Lr.No. D.Dis. A/11039/89 dated 15.9.'89.

Sub: MMDA - Planning permission - construction
of Residential building - Plot No.326 at
S.No. 257 of Porur village - approval - Reg.

SITE PLAN SHOWING THE PROPOSED BUILDING
IN PLOT NO. 326, MANGALA NAGAR-EXTENSION.
SURVEY NOS. 216, 251/2, 253, 254, 255/1,2, 256/1,2, 257, 300/1,2, 301, 302.
AT VILLAGE NO.98, PORUR-Saidapet, taluk. CHENGALPET DISTRICT.

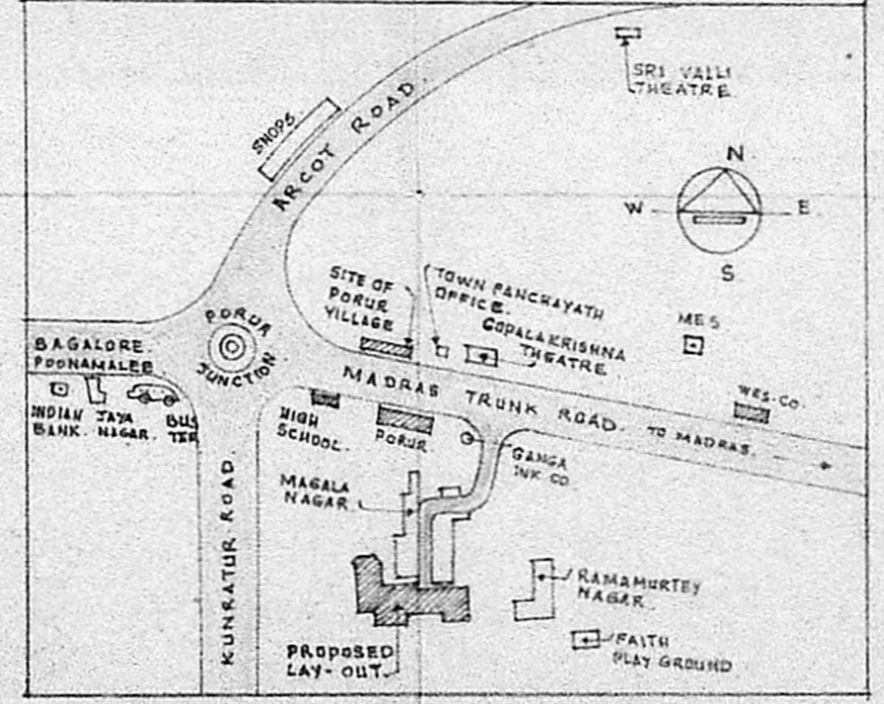
- i) 'in the open space within the site to the extent feasible trees be planted and the existing trees preserved'
- ii) 'it was requested to ensure that the plans for the new buildings will incorporate the approved designs for mosquito-proof overhead tanks and wells'
- iii) 'other charges as applicable'
- iv) **After obtaining the revised plan showing the splay 3Mx3M.**
